CITY OF ALBUQUERQUE

July 14, 2015

**Re: A.I.S. Retail
Grading and Drainage Plan (H13D106)
Engineer's Stamp Date, 7-9-15, 7-7-15 & 6-25-15 (Sheet C1, C2 & C3)**

**A.I.S. RETAIL**  
**SITE GRADING & DRAINAGE**

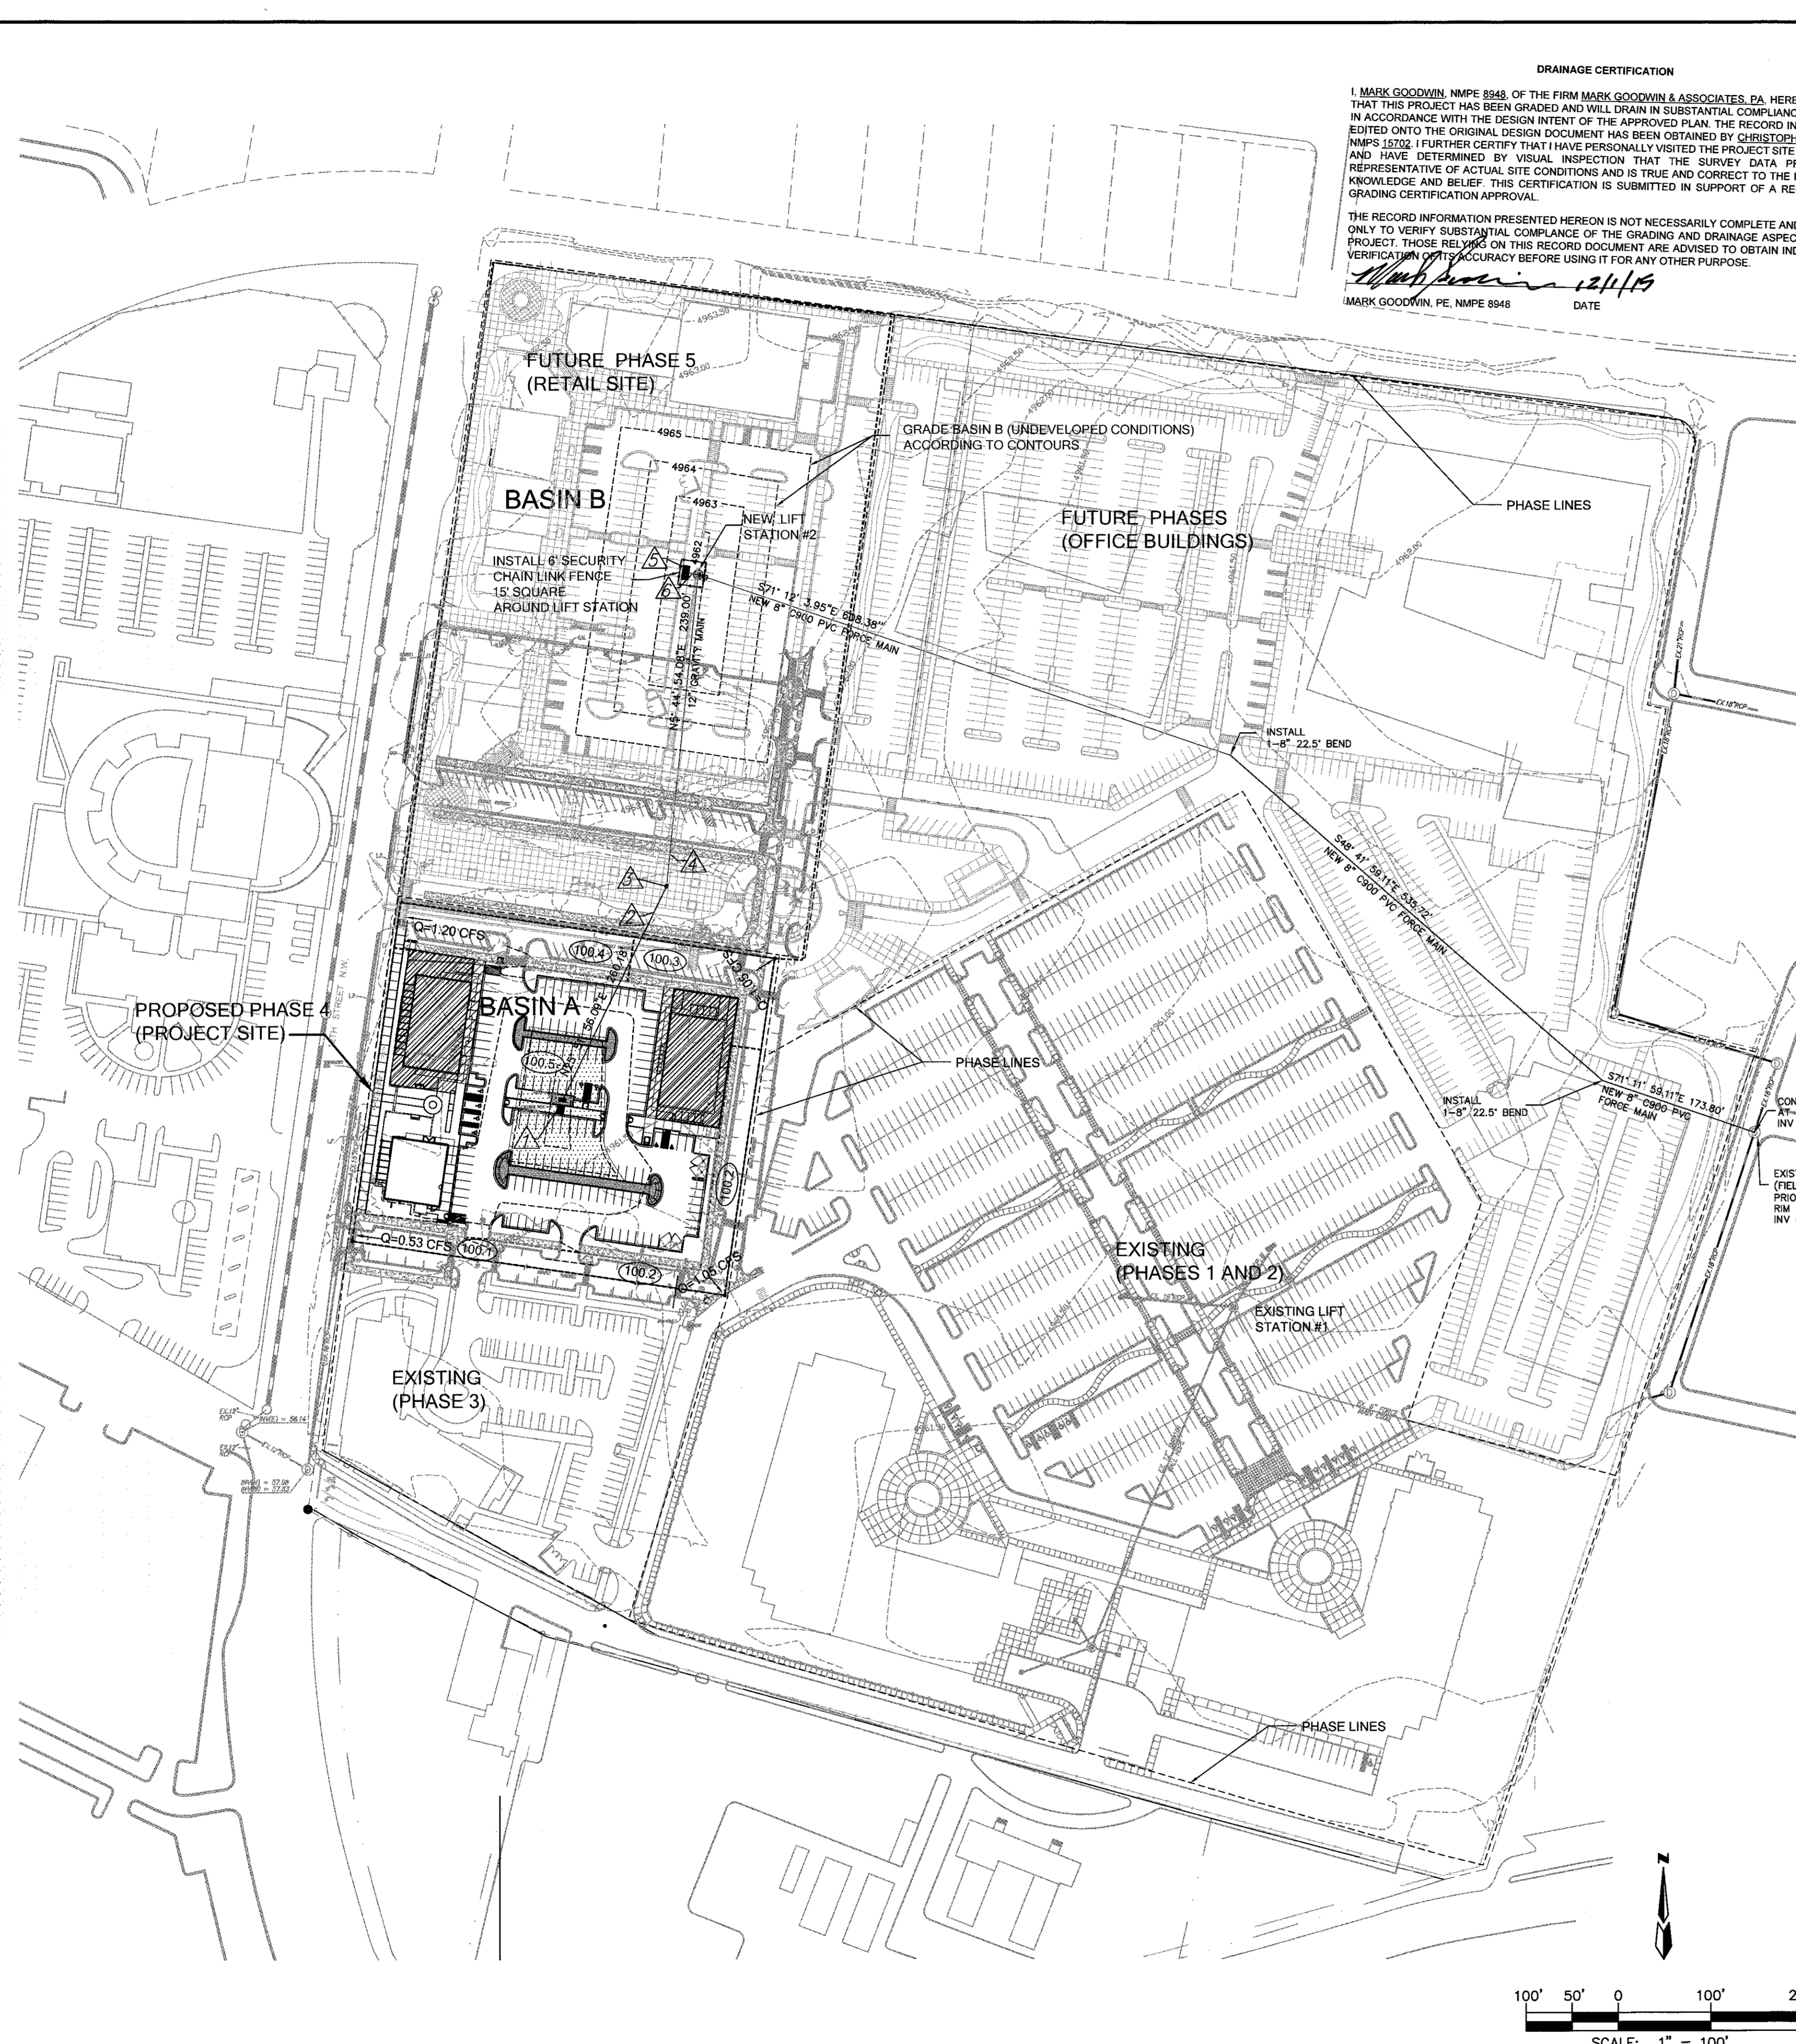
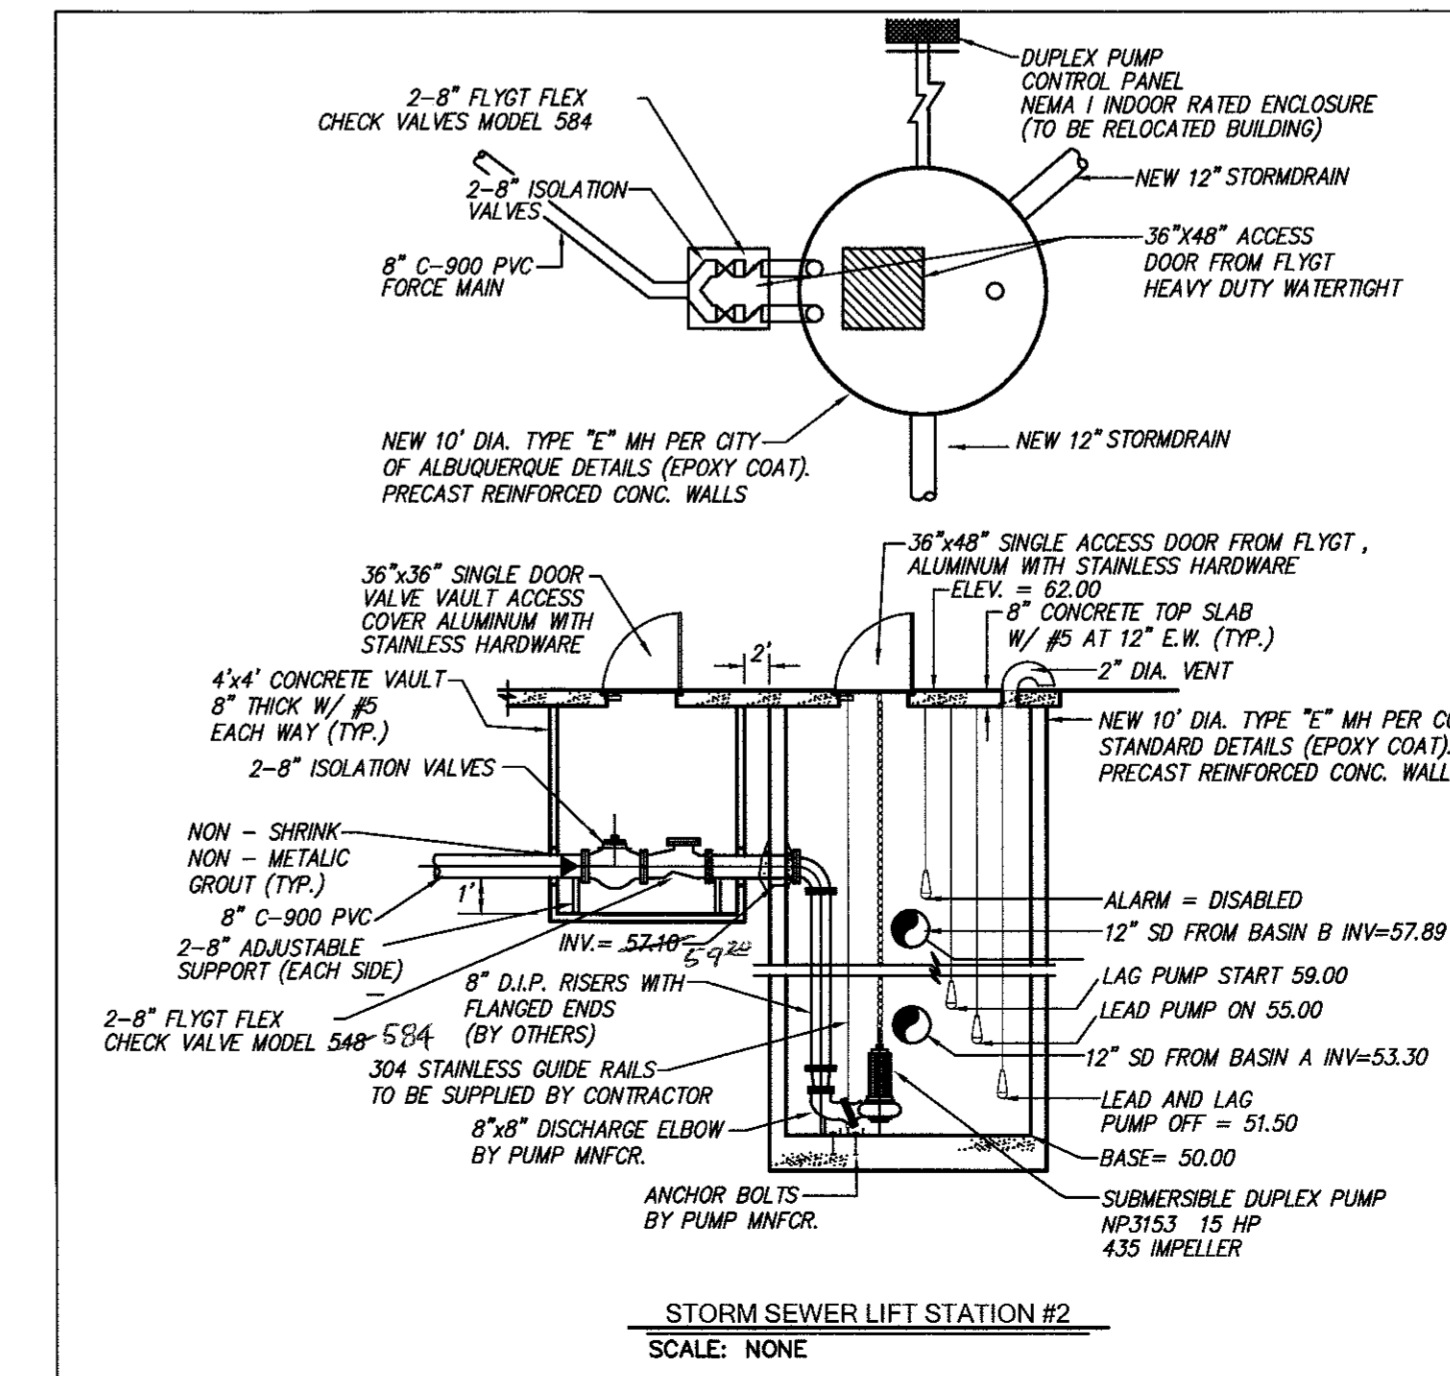
- Show roof flow directions. Runoff west of the building along 12th street cannot drain over the sidewalk to the west.
- There appear to be some ponding between the two buildings along 12th street.

- Provide additional spot elevation to assure that the runoff will be able to get around the back of the building and into the parking lot.
- Provide elevations for the trash enclosure floor drains.

- Show the 100-year water surface elevation on the plans. The water depth appears to be more than 24" in the parking lot. Provide your routing calculations for the parking ponding. Where is the emergency overflow?

- Please provide the bottom of the pond elevations where first flush ponding is proposed. Some areas along the parking lots may have more than 18" of vertical drop. Therefore, handrail will be required. A retaining wall should be used for these areas.

- Is the grate elevation for the double "D" inlet at the bottom of the pond? How does the sidewalk culvert tie into the double "D" inlet?
- There is a proposed sidewalk culvert north side of the southerly building along 12th Street. The culvert encroaches into the handicap ramp. Is the runoff draining to the depressed landscaping area to the southwest corner of the building? Can the runoff be routed to the parking lot? How much runoff is being routed to this area?

## A.I.S. RETAIL OVERALL STORM DRAIN DESIGN

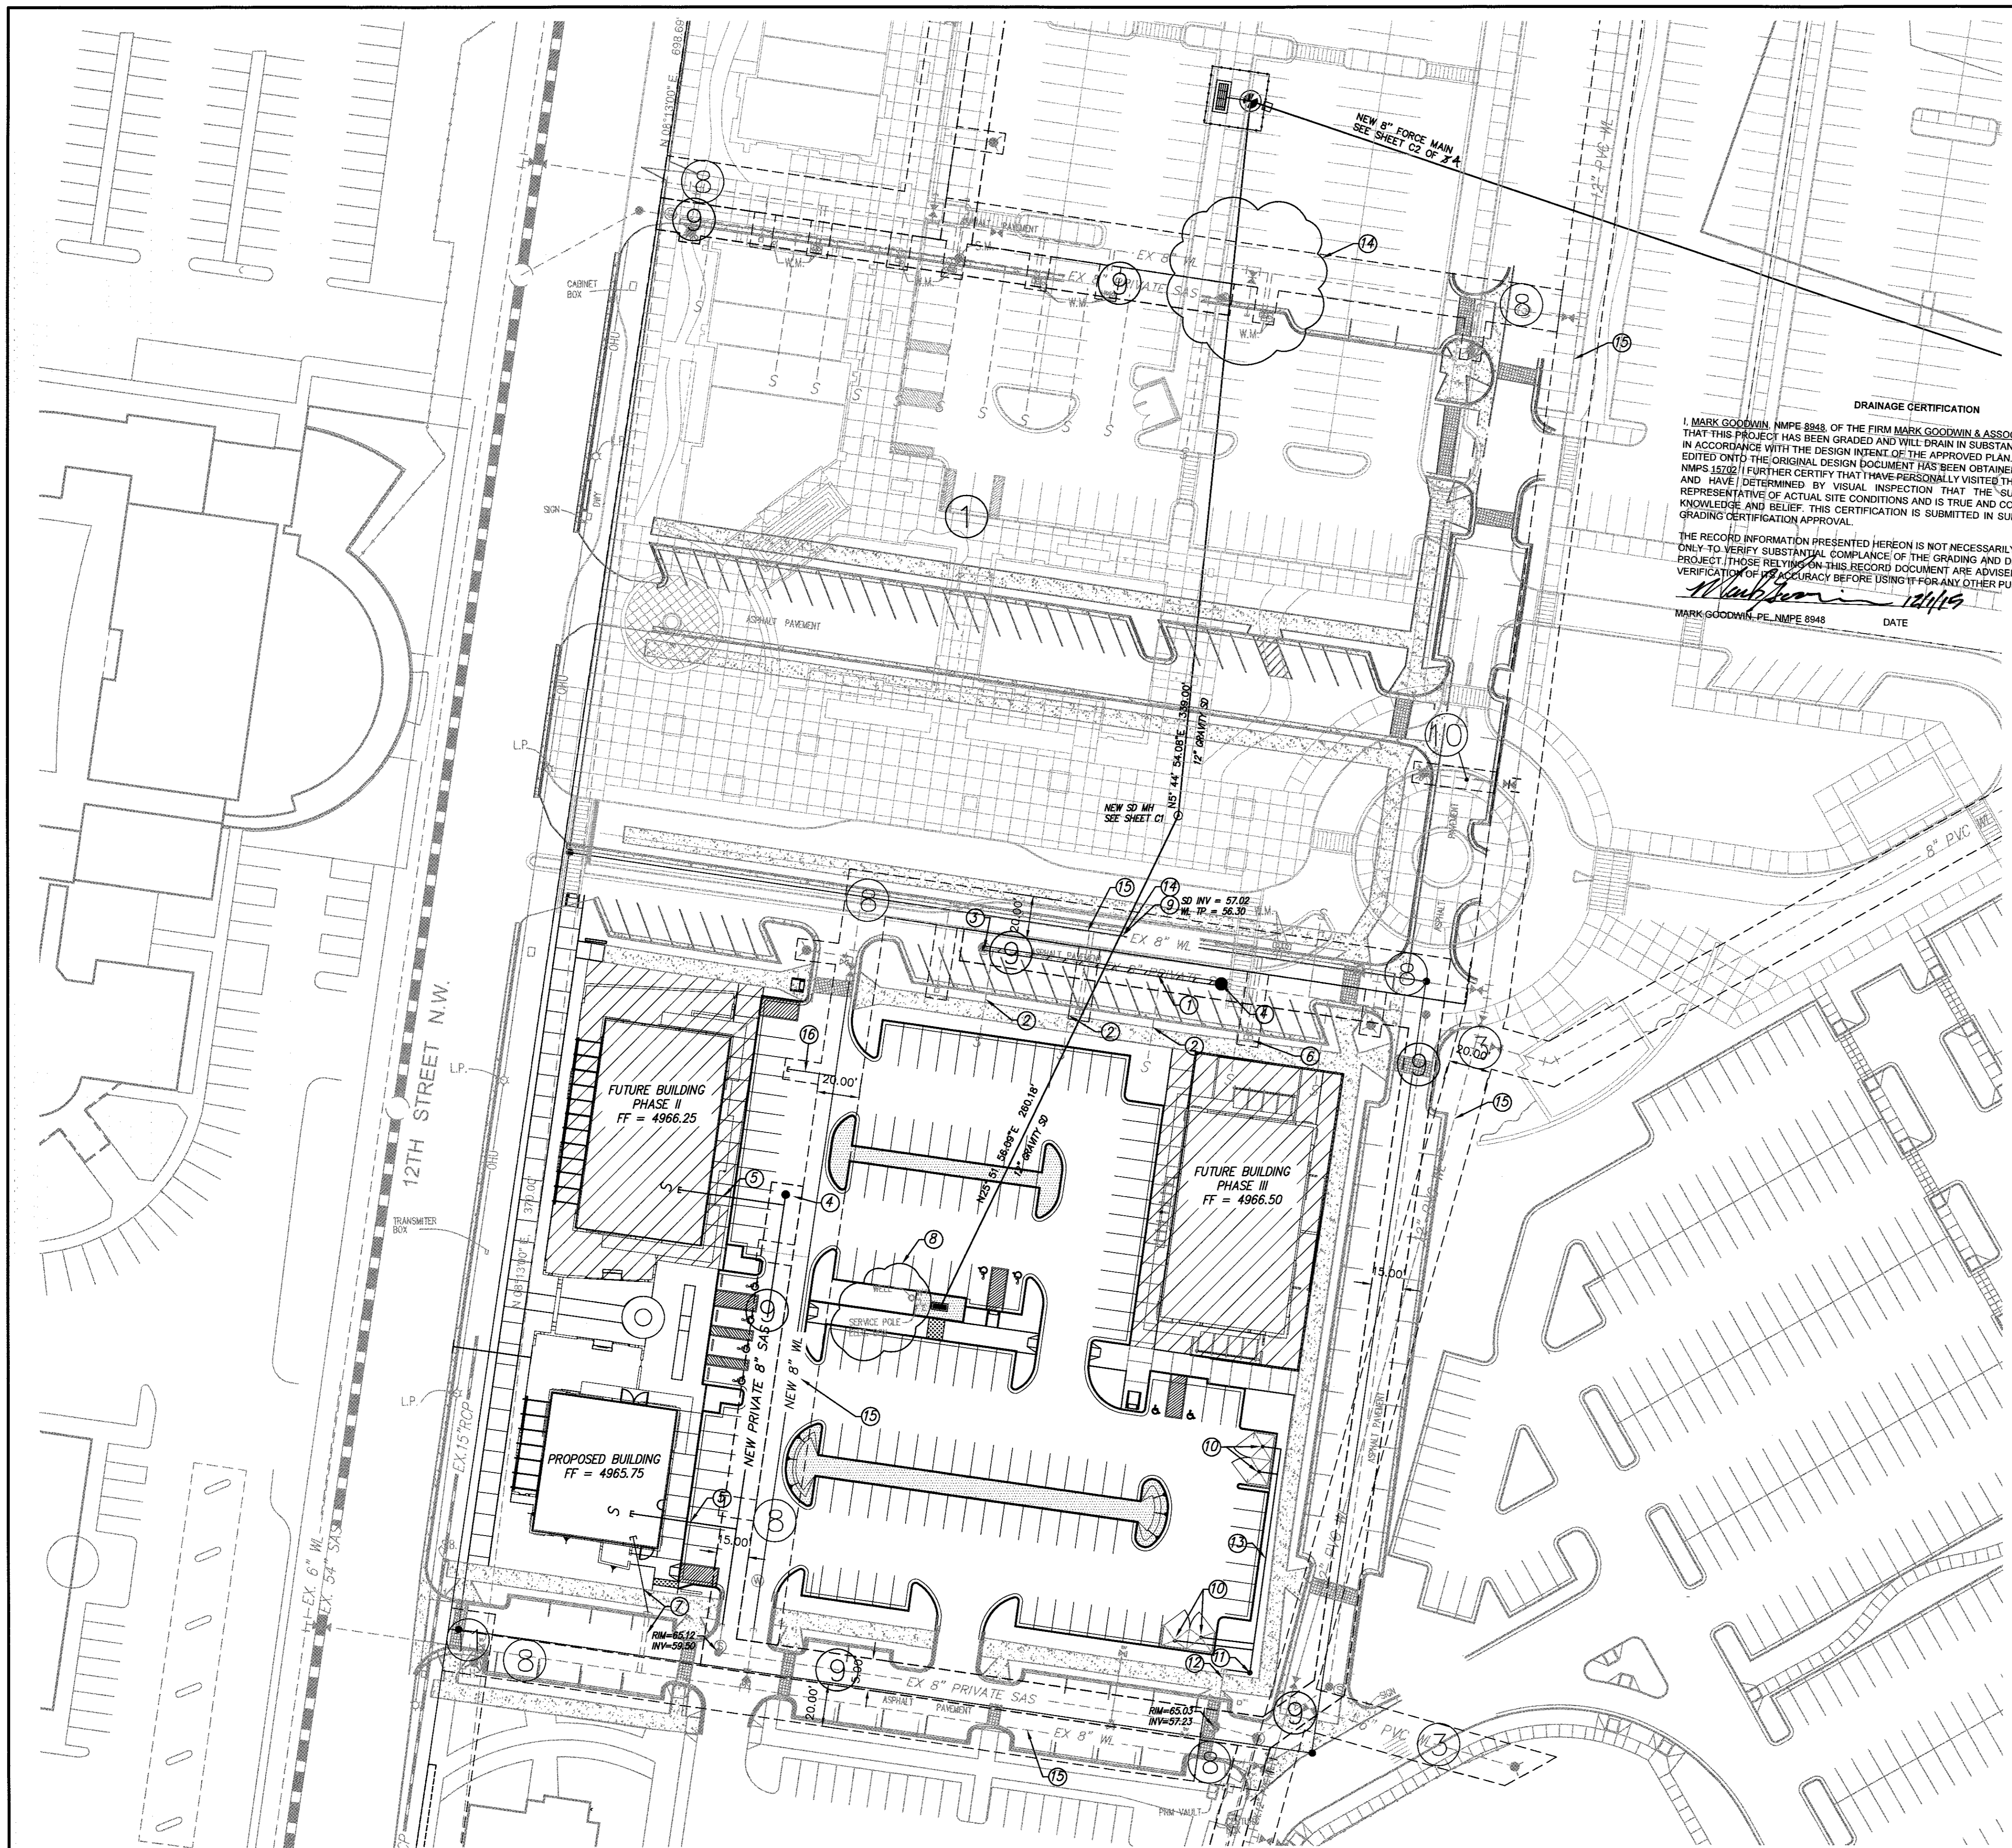
- Please correct the force main line size on sheet C3 of 3.
- Show existing contours. Provide contour elevations on sheet C2 of 3.
- Who will be maintaining the storm drain system?
